CITY OF ALBUQUERQUE

**RE: TLC Plumbing Office/Warehouse
Grading Plan and Drainage Report
Stamp Date: 4/14/17
Hydrology File: G15D032**

Based upon the information provided in your re-submittal received 4/14/2017, the Grading Plan and Drainage Report is approved for Building Permit and Site Plan for Building Permit.

**RE: TLC Plumbing Office/Warehouse
Grading Plan and Drainage Report
Stamp Date: 2/24/17
Hydrology File: G15D032**

TLC WAREHOUSE GRADING DRAINAGE PLAN

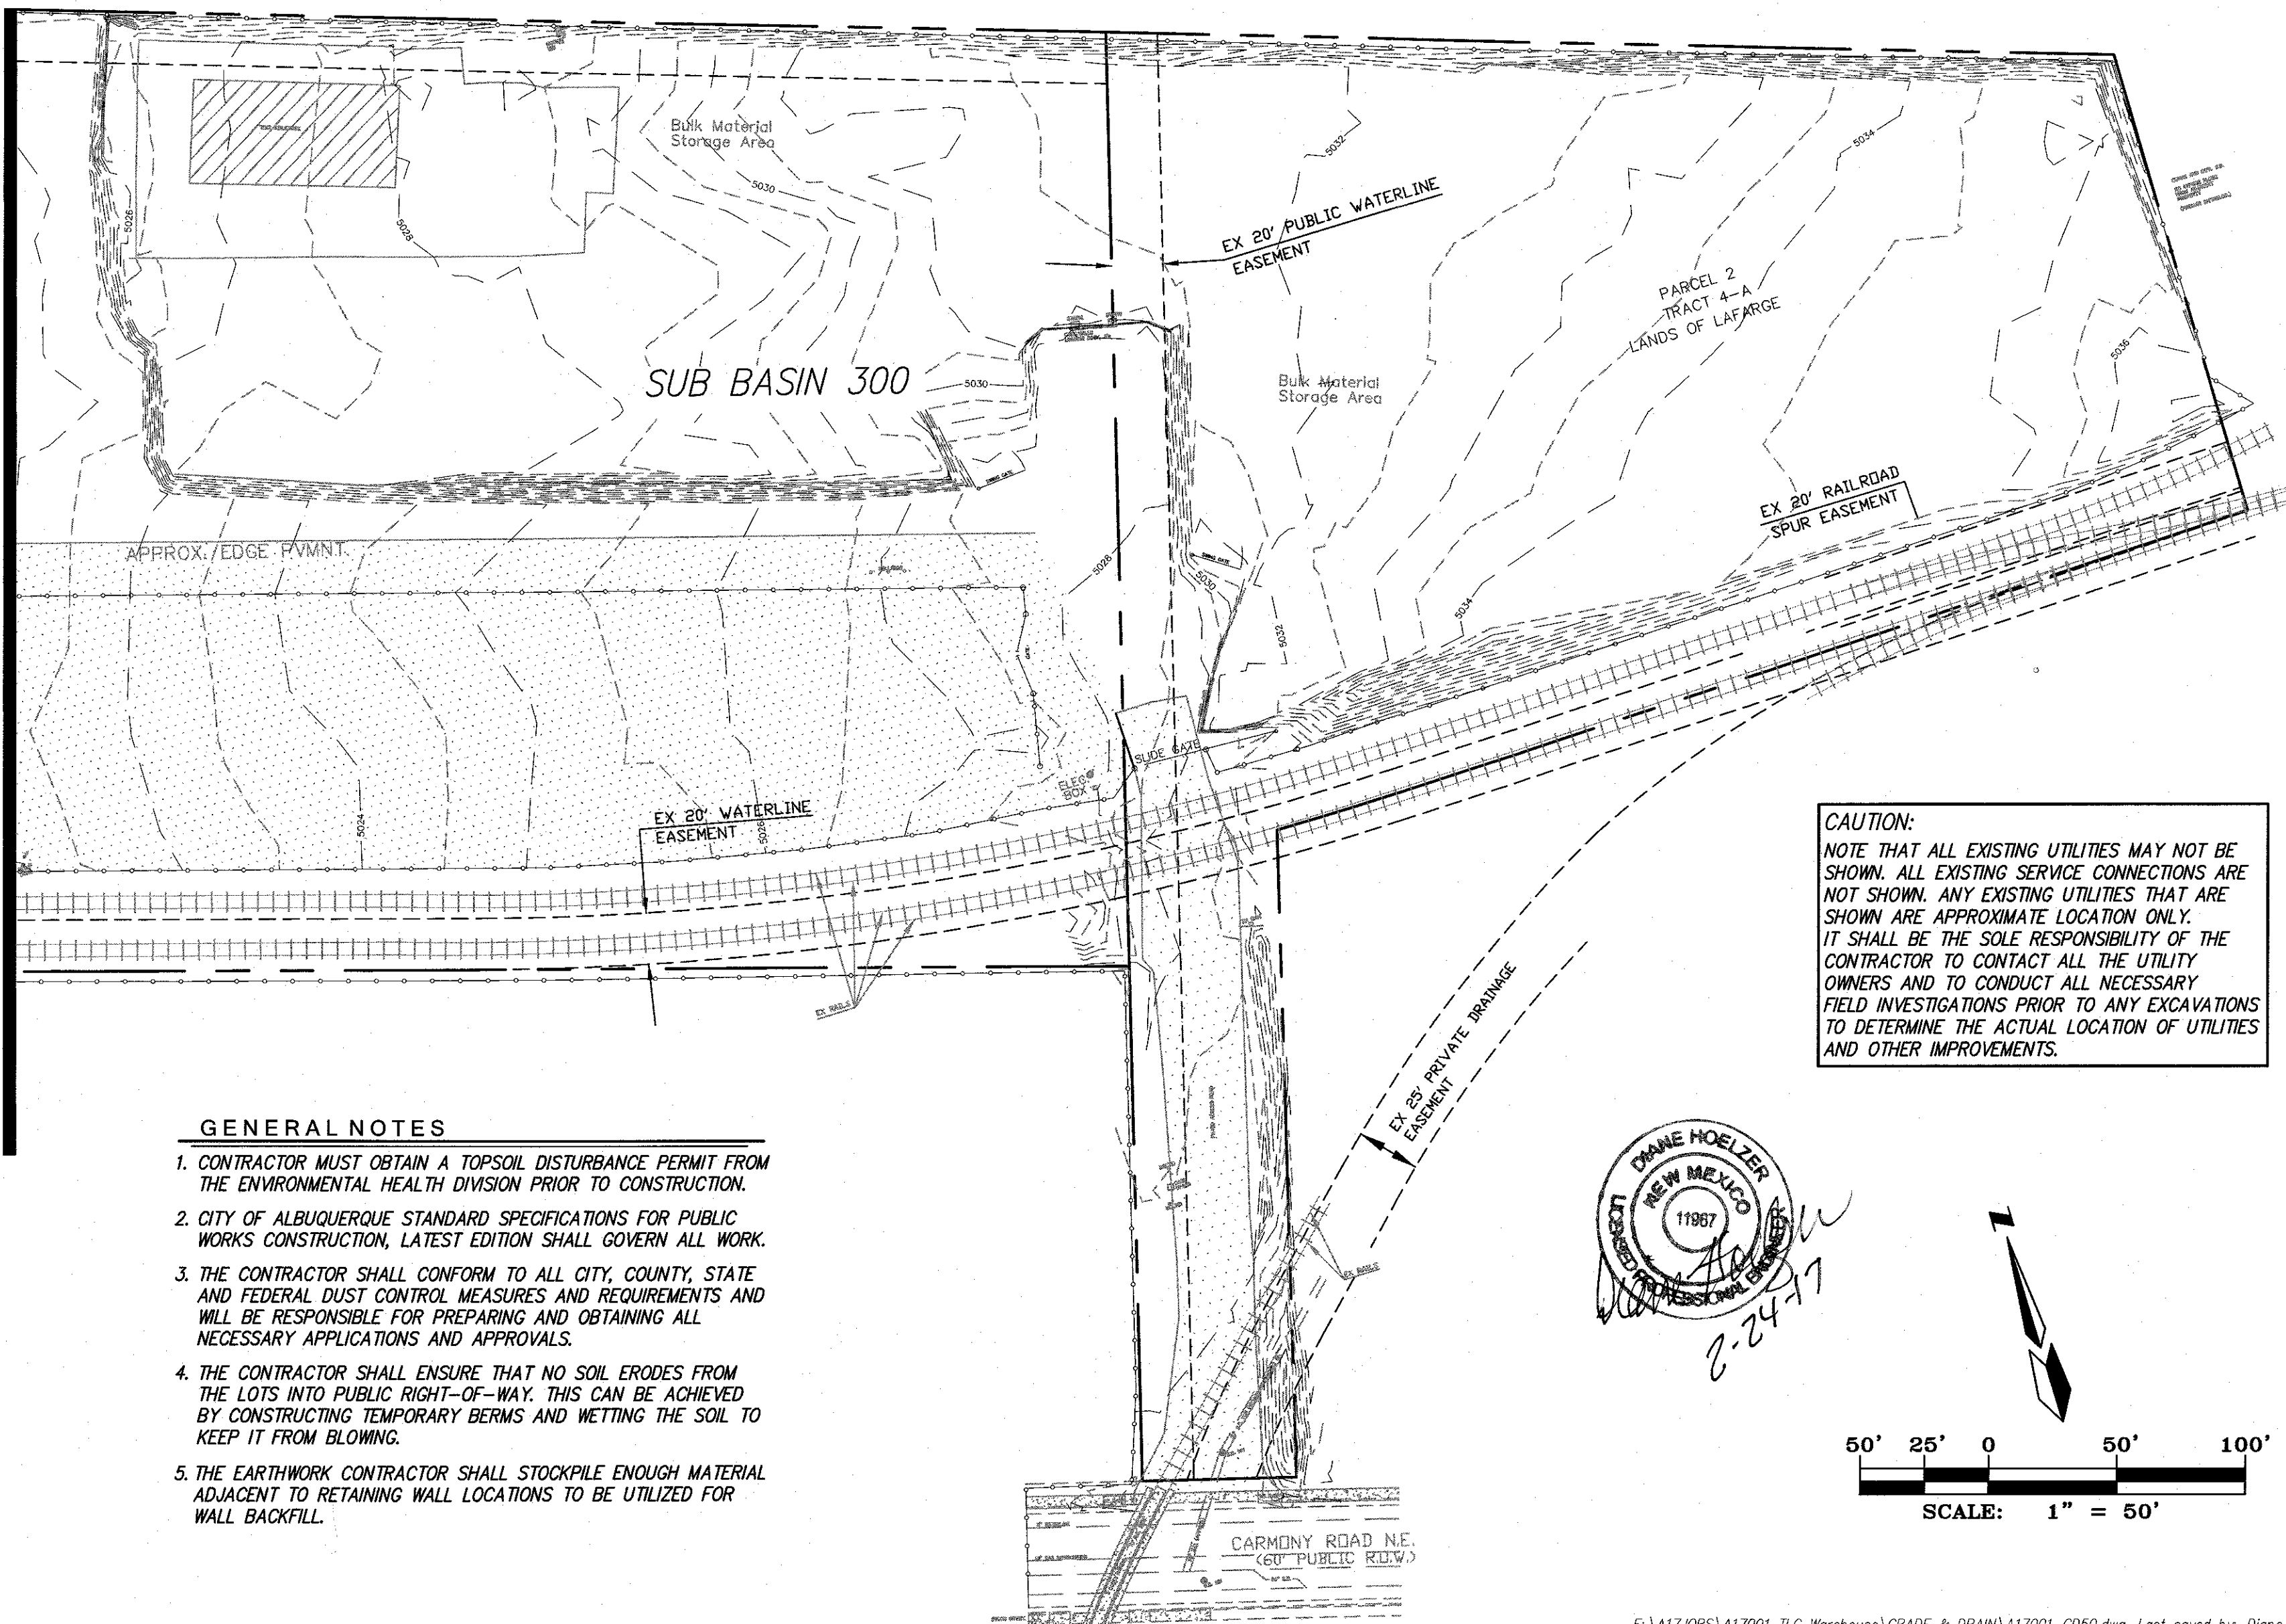
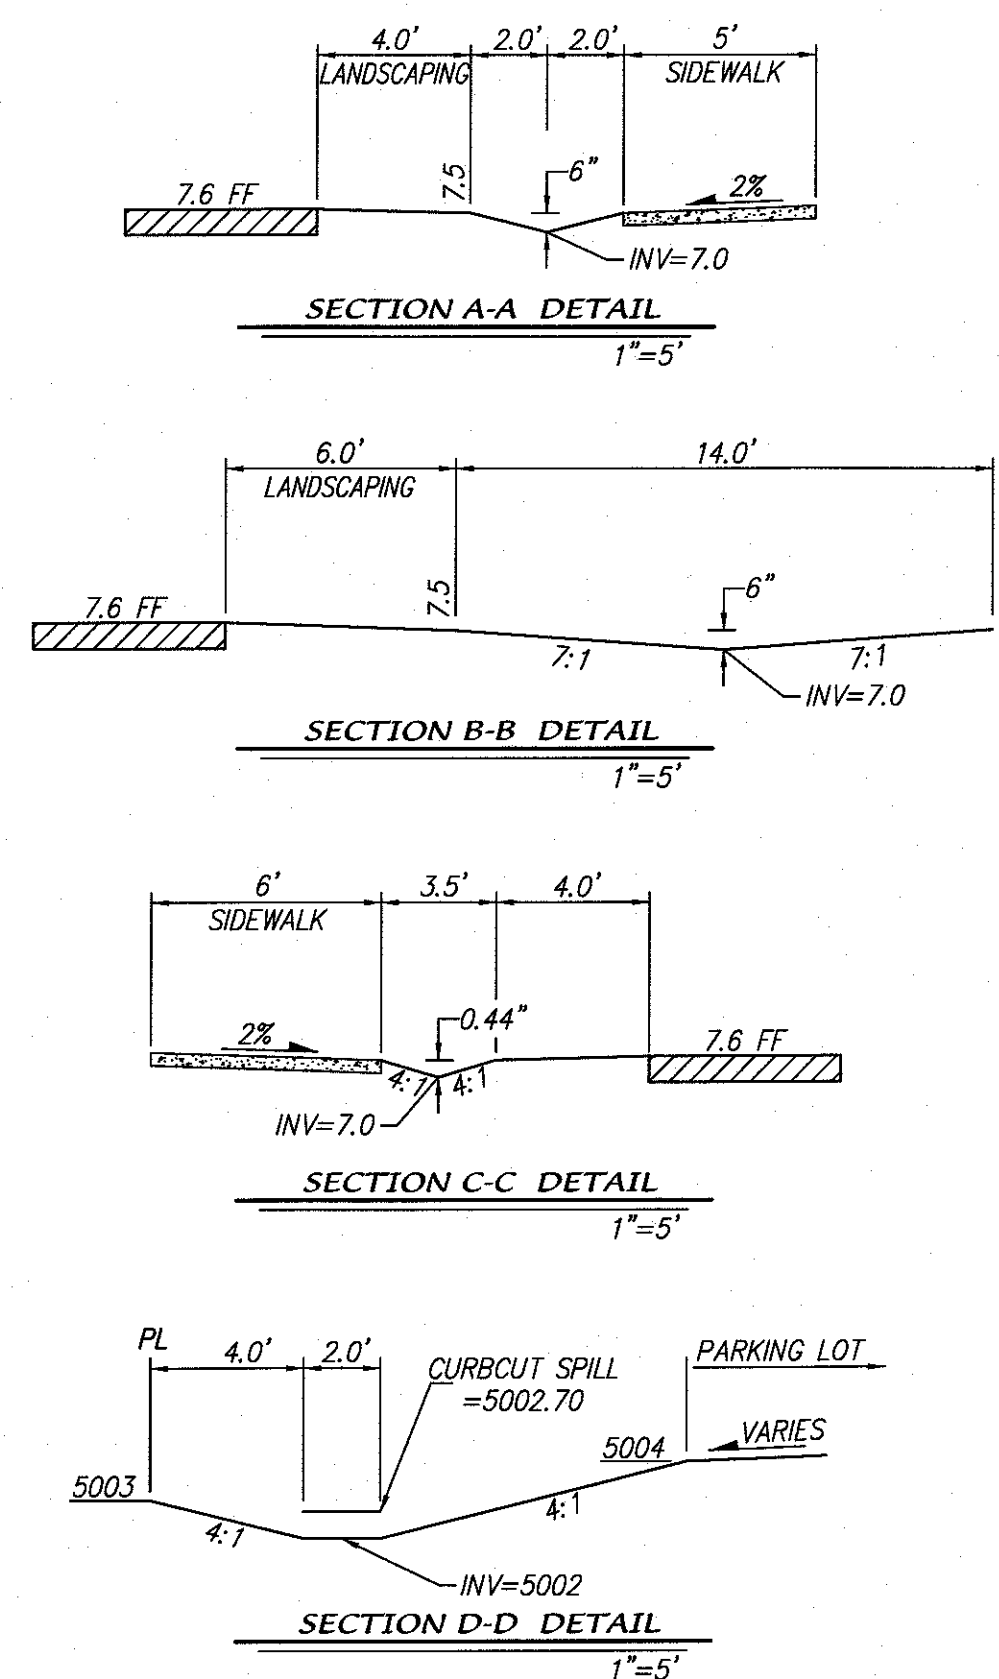
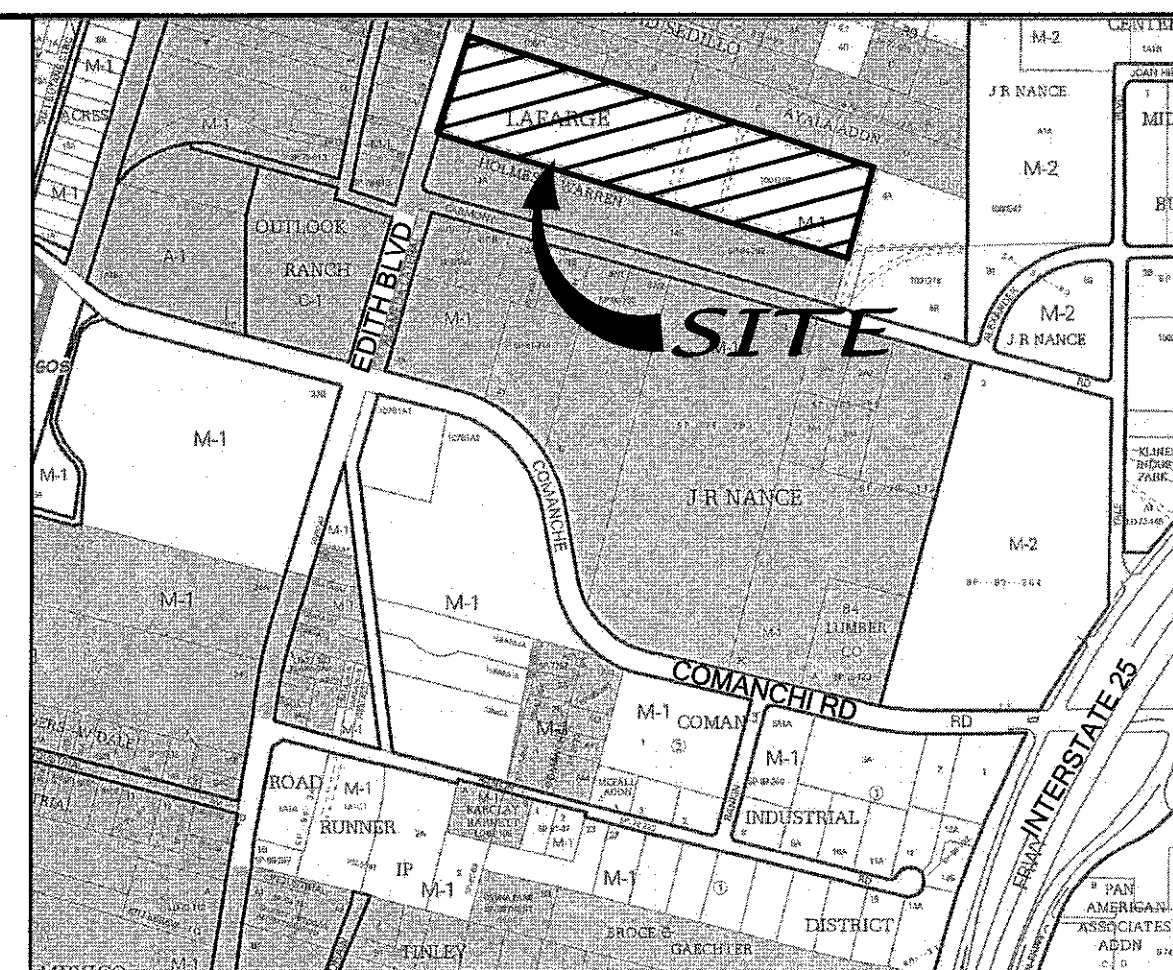
1. Please show a cross section for Sub Basin 100 and label the size and depth of the rock for the drainage swale.

1. As a follow up to our phone conversation, I sent you the as-built for the SAD storm drain in Edith Blvd. All the drawings I could find lack information on what the SAD identification number is. The SAD drainage criteria was taken from a prior approved and as-built grading and drainage plan for this site done by our office. This should also be in the hydrology files under the same name.
2. Refer to Figure 4 for a summary of all the hydrology for this site.
3. The maximum allowable discharge was calculated to be 71.7 cfs based on the 20% Treatment B and 80% Treatment D criteria. The peak developed flow from the entire site was calculated to be 47.5 cfs. This is stated in the report text now.
4. Done.
5. Please refer to Figure 4 and the AHYMO printouts in the appendix.
6. A cross section of the swale that has been shifted to the north boundary is now show on the plan.
